RE: RESPONSE TO SUBMISSIONS - CAMDEN MEDICAL CAMPUS - SSD_7387

Appendix 1

Response to Agency Submissions

Title  
Gregory Hills Corporate Park  
Camden Medical Campus  
Civil Works  
Stormwater Drainage Details  
Sheet 1

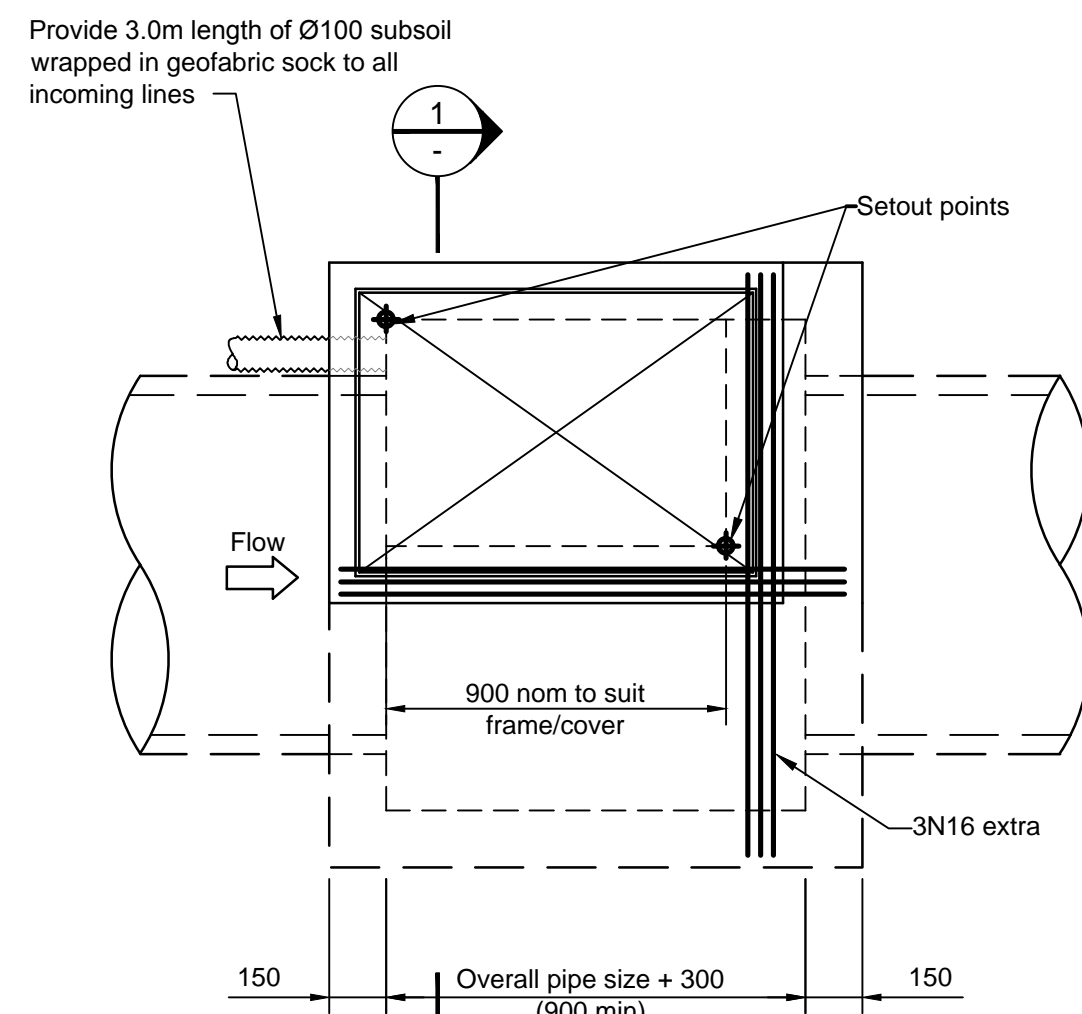
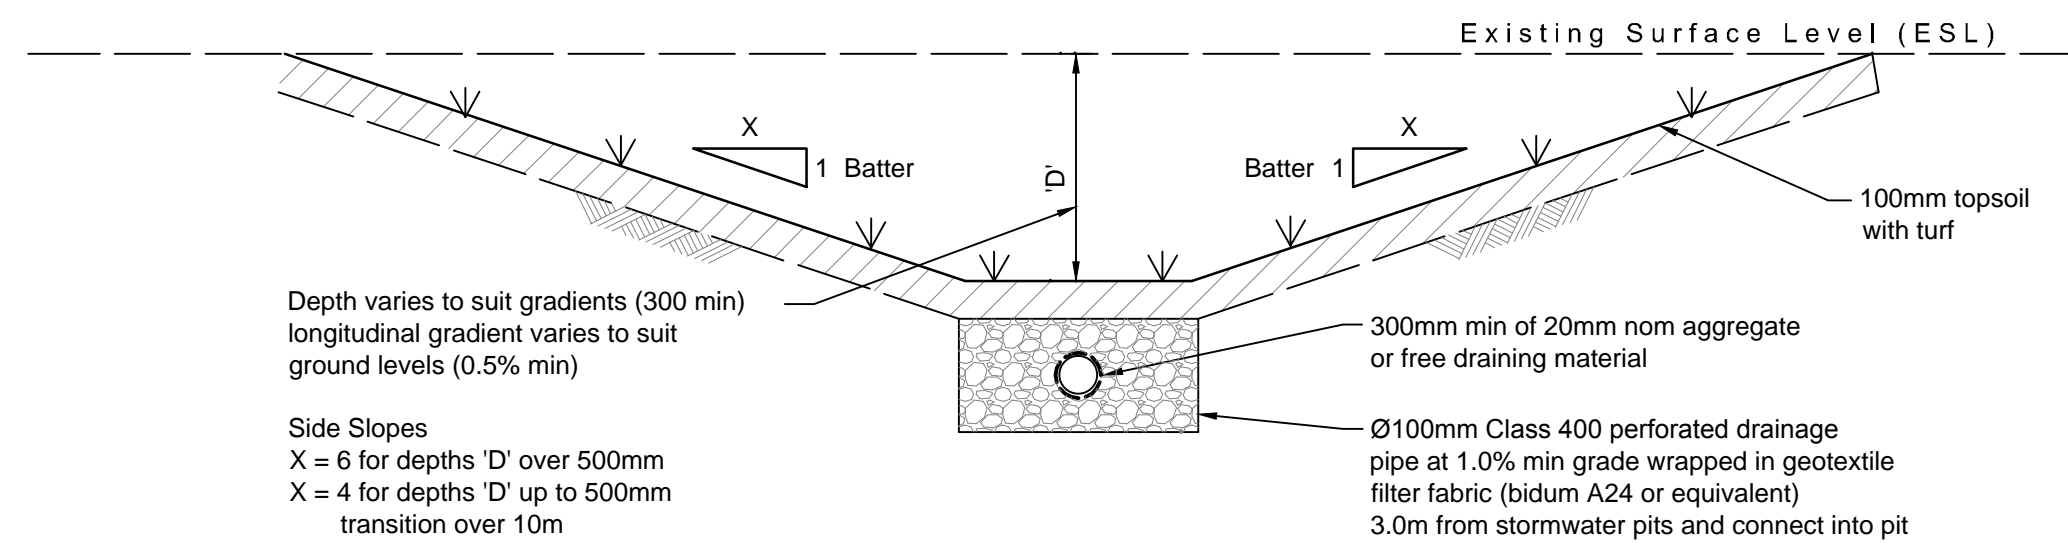
As above	A suitable pump out system for the basement car park must be provided.	The response by Mott MacDonald at Appendix 4 addresses this issue, with an extract provided below: <i>"Noted. This design will be undertaken during the detailed design. This design will be undertaken during the detailed design."</i>
As above	The applicant may consider an alternative OSD basin as the proposed underground tank being approximately 20m x 35m over a two way road, as scaled off from the submitted plans, could be difficult and impractical to construct. An alternative could be an above ground basin.	The response by Mott MacDonald at Appendix 4 addresses this issue, with an extract provided below: <i>"Noted. Alternative solutions have been suggested in the stormwater and servicing strategy report such as utilising pipe capacity by upsizing the pipes in the site, this will be looked at during the detailed design. Above ground detention was looked at but was not considered acceptable due to the area constraints on the site."</i>

Title  
Gregory Hills Corporate Park  
Camden Medical Campus  
Civil Works  
Simulated Vehicle Manoeuvres  
Sheet 1

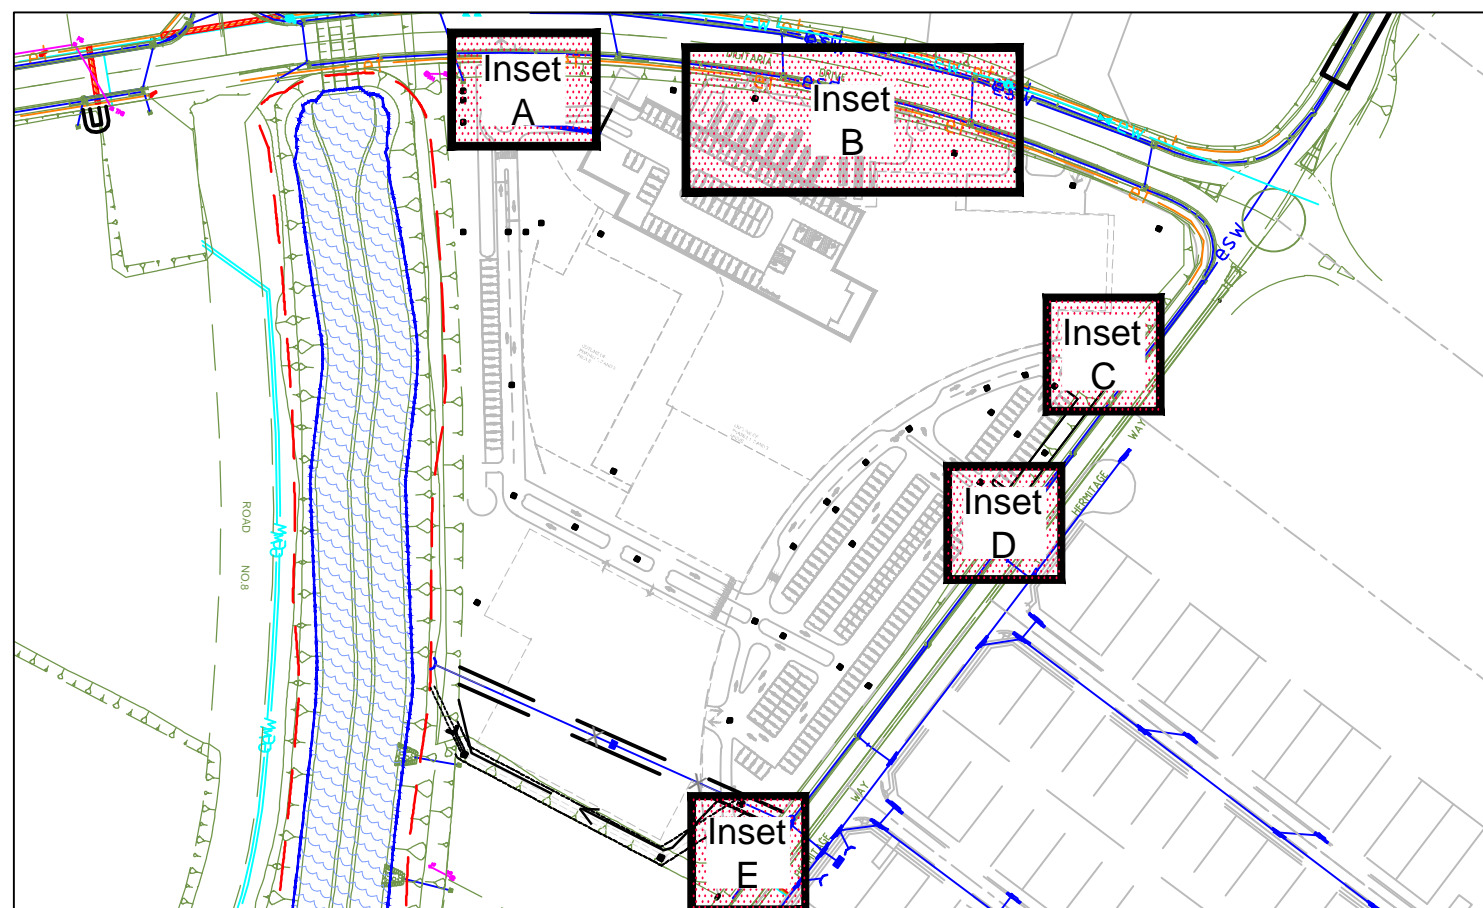
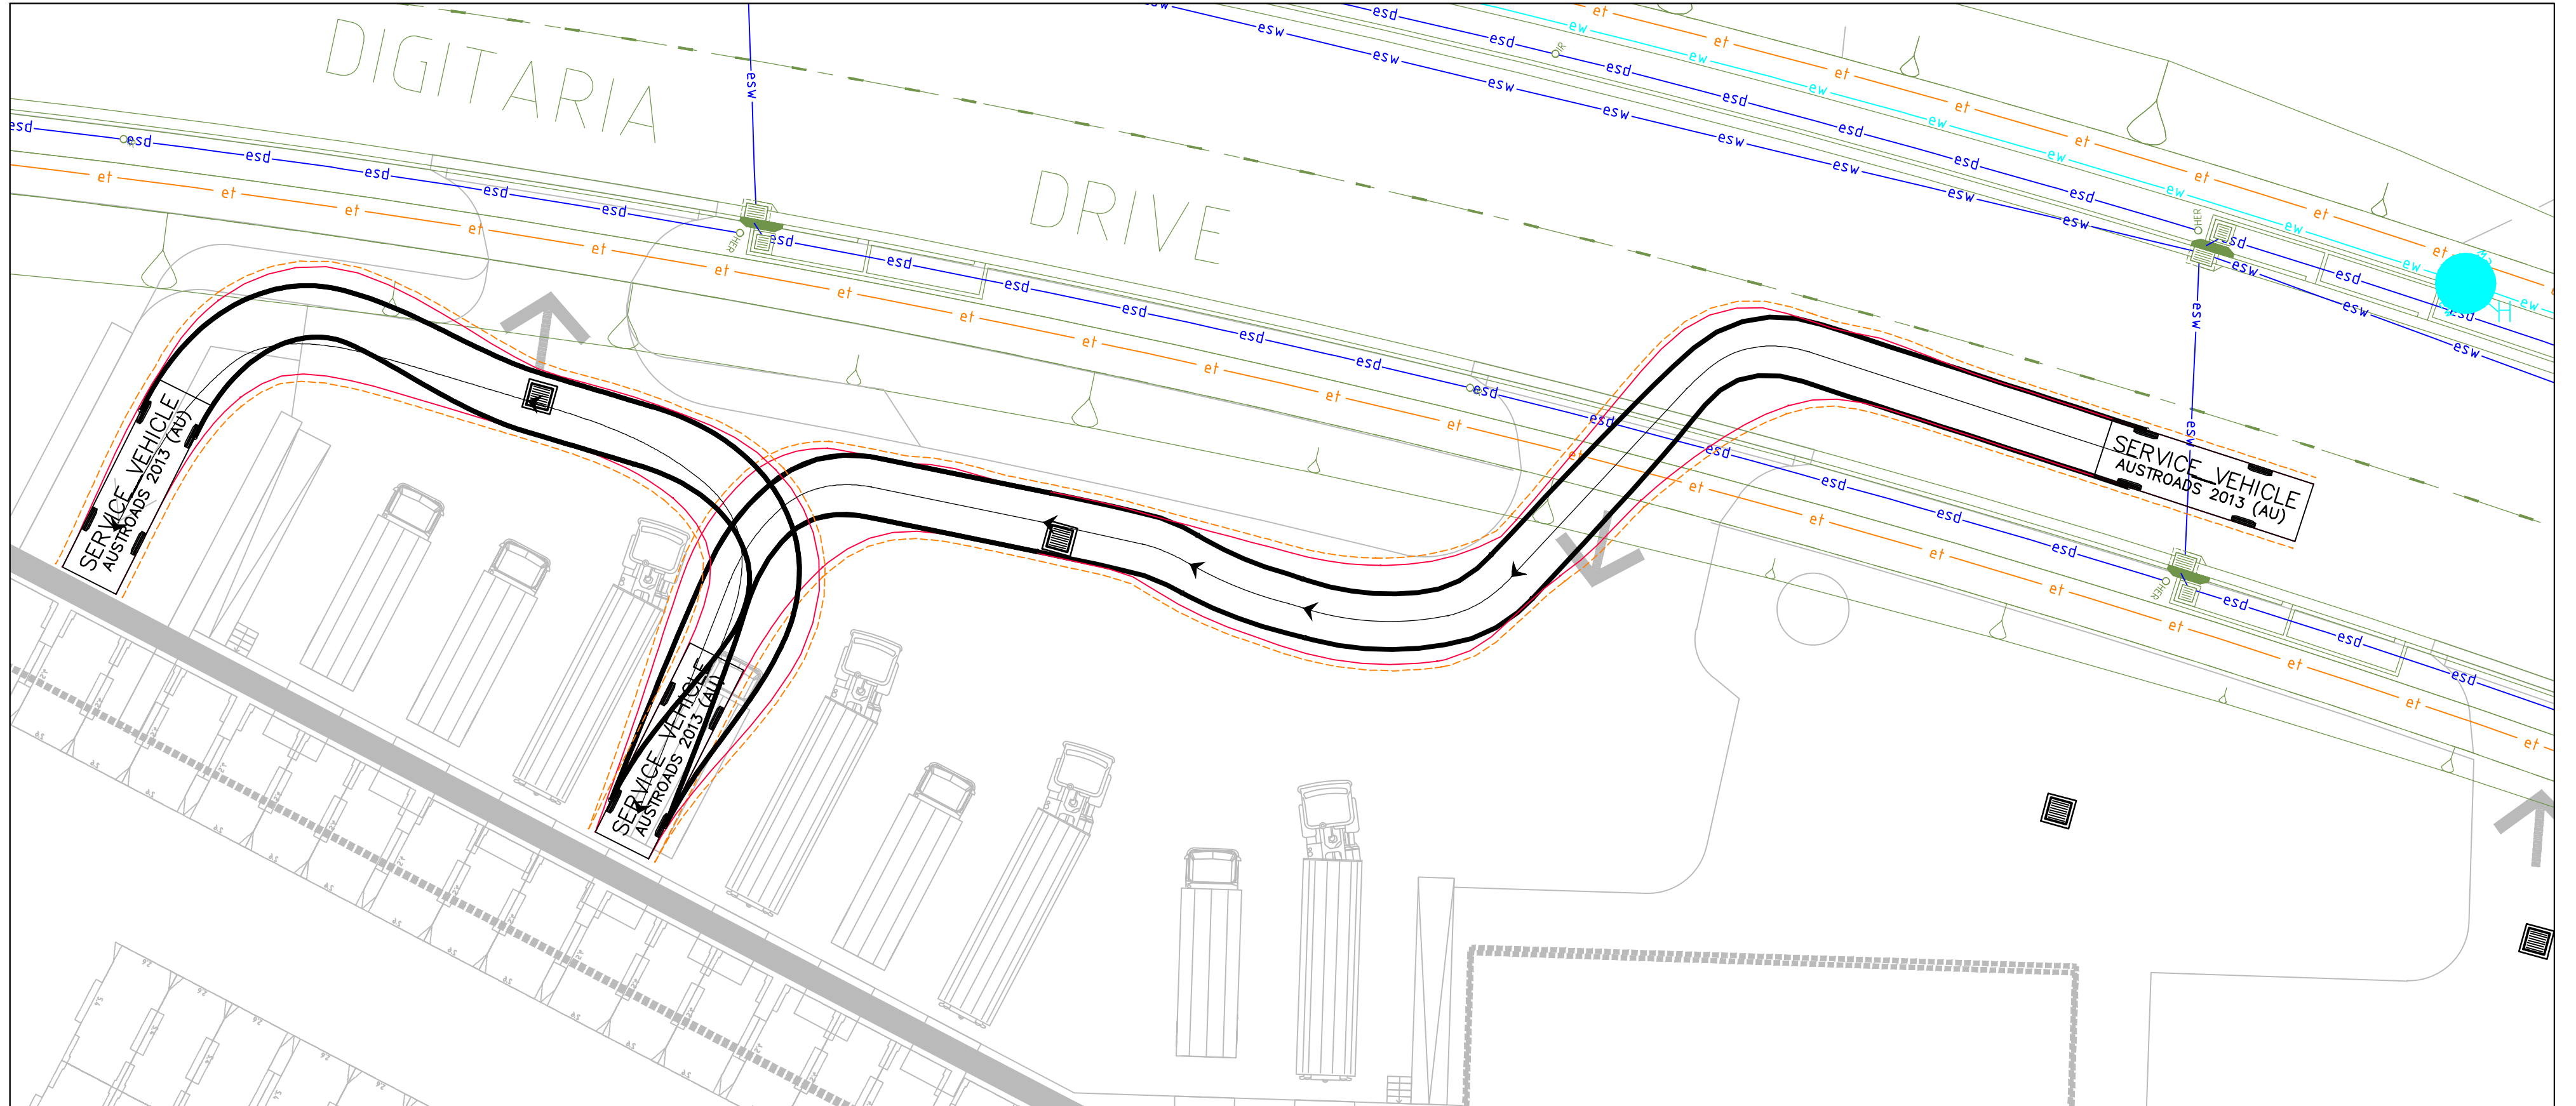
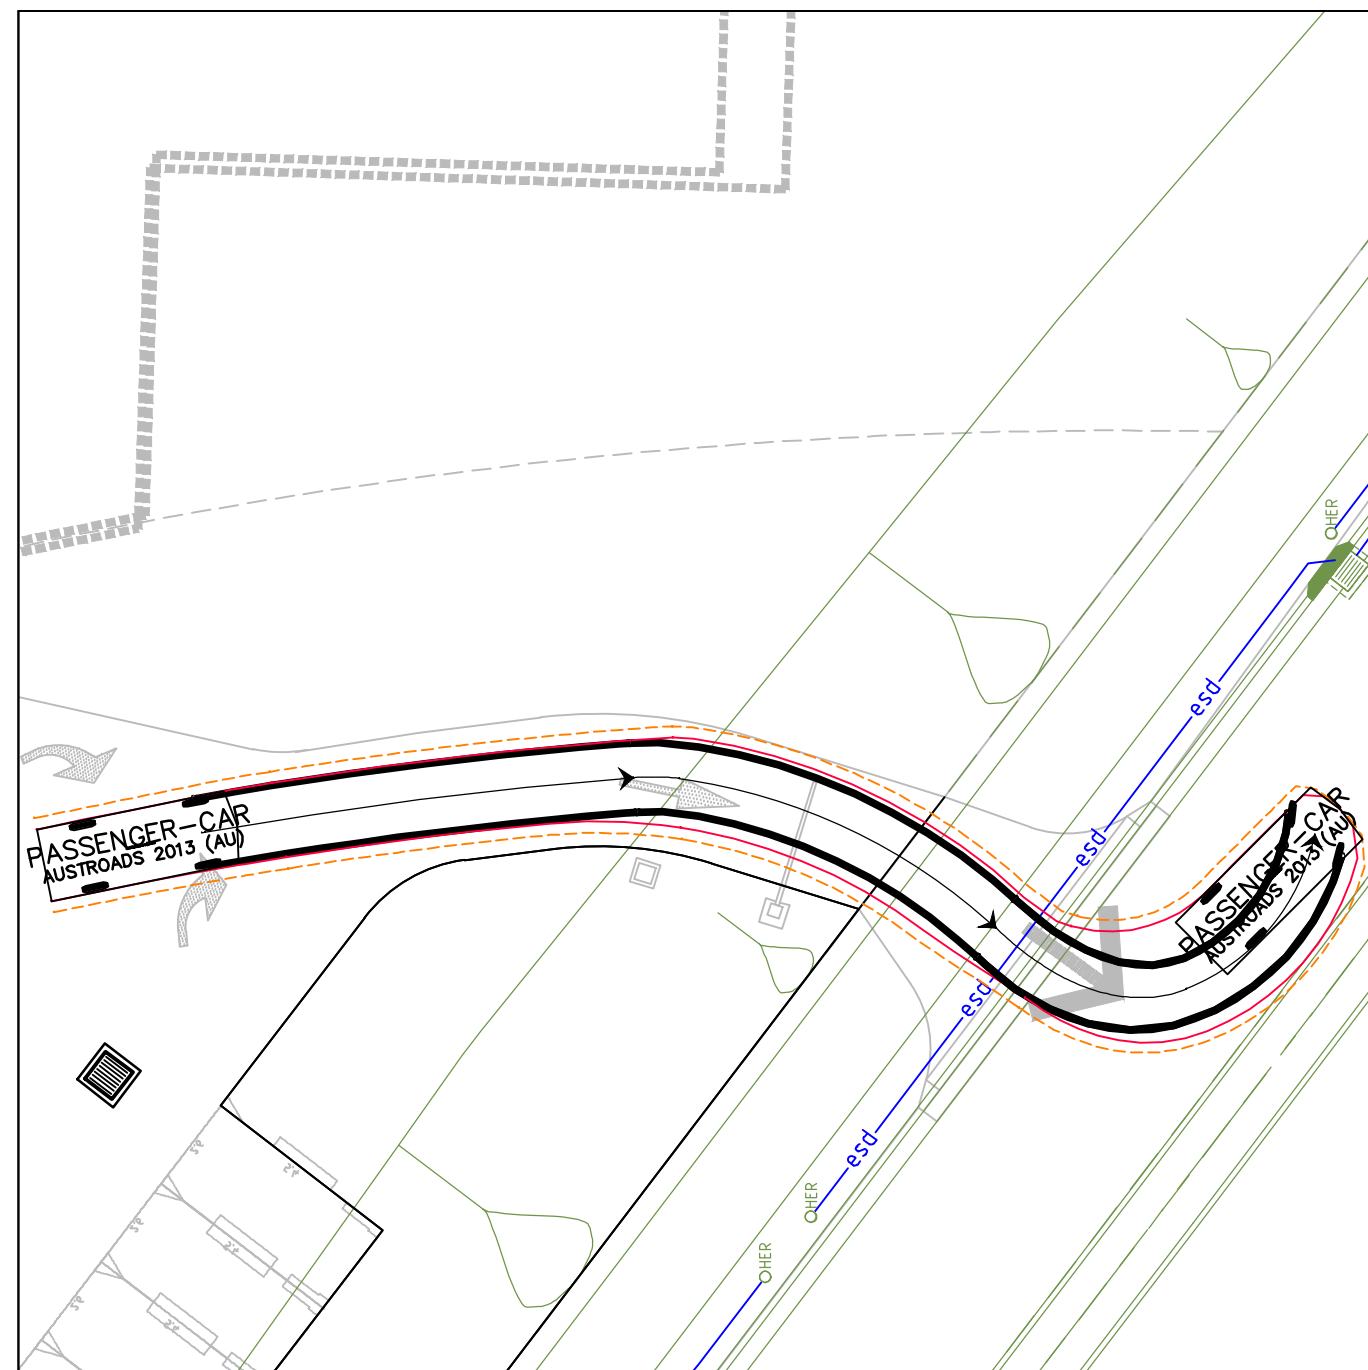
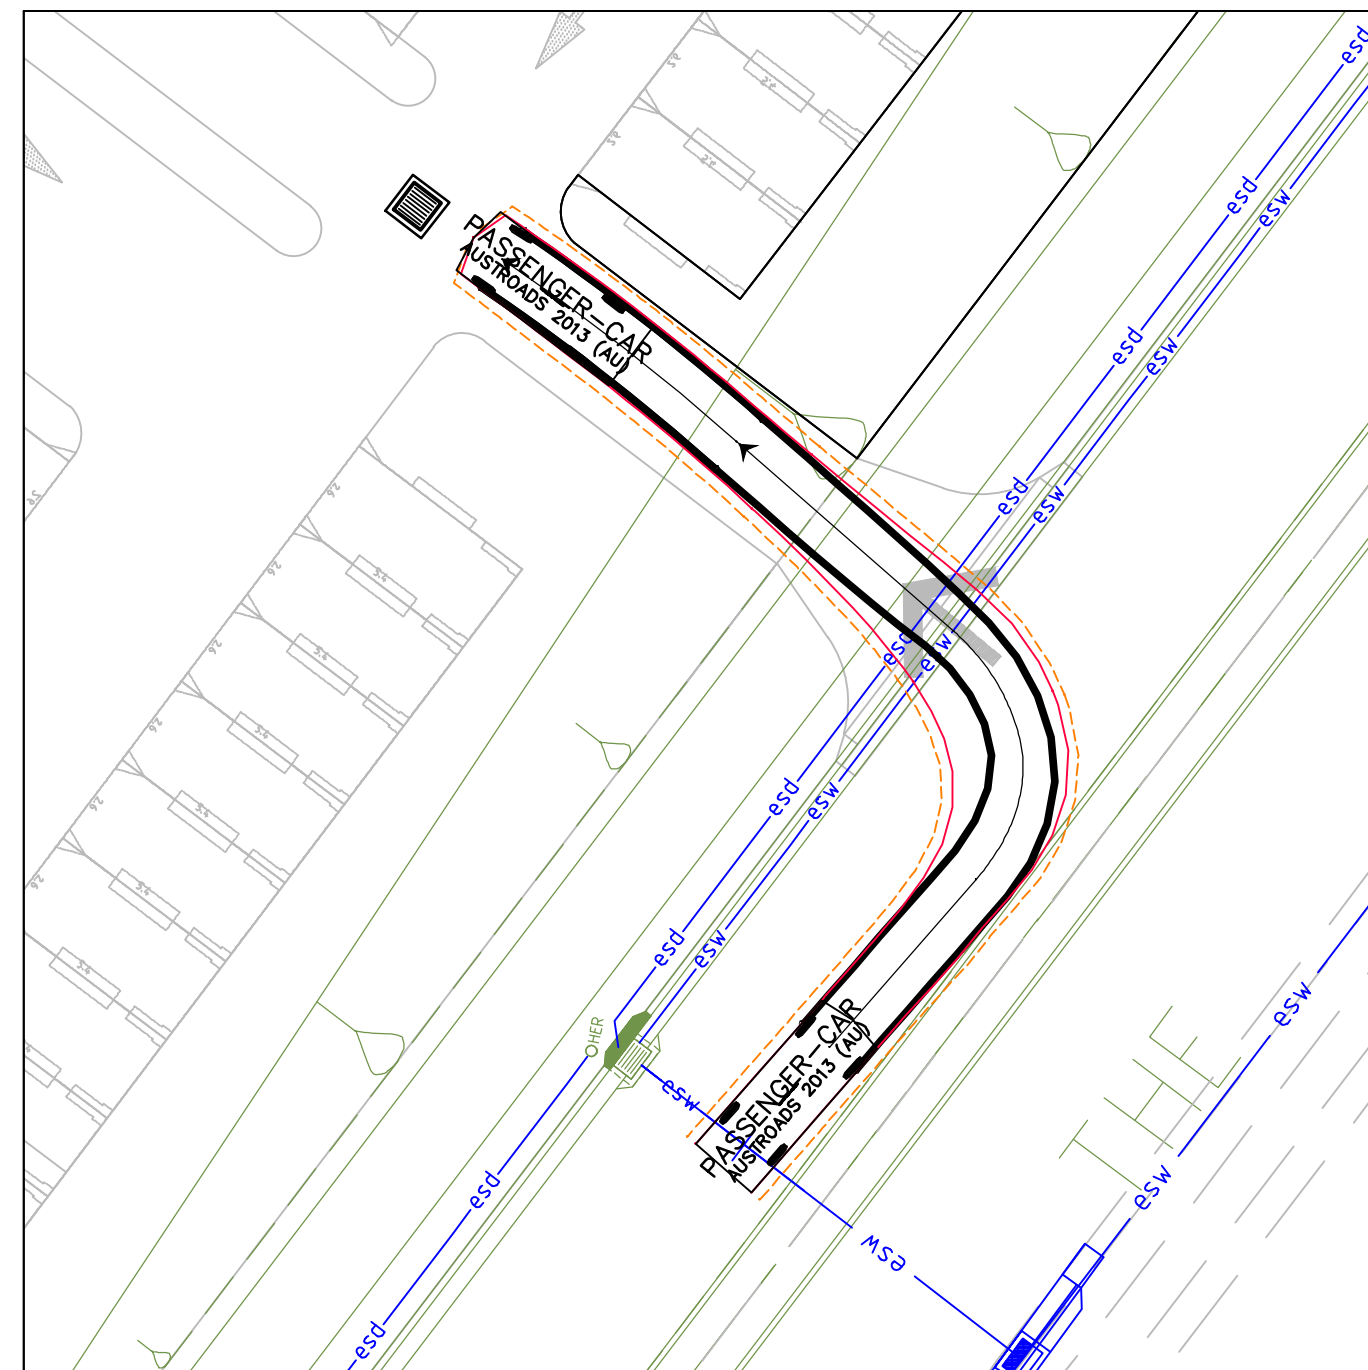
As above	Further details on loading and servicing are required, including how many vehicles are expected per day and the sizes of those vehicles. The detail provided indicates 12.5m vehicles are to service the site. Is this adequate or will larger vehicles be required? No dimensions of any loading bays have been provided. A loading/service management plan should be prepared to ensure vehicles are not waiting on public roads in order to access the site.	<p>The response by Mott MacDonald at Appendix 4 addresses this issue, with an extract provided below:</p> <p><i>"A large number of service bays are proposed and this allows for operational flexibility. The design provision is also noted to be above what is typically provided at similar developments. The turning path analysis confirmed that the allocated loading bay areas within the concept plan are sufficient to accommodate the design service vehicle that has been determined for the site. Refer to section 4.5 and appendix I in the Traffic Impact and Parking Assessment for further information. Further details will be provided as part of future staged planning submissions."</i></p>
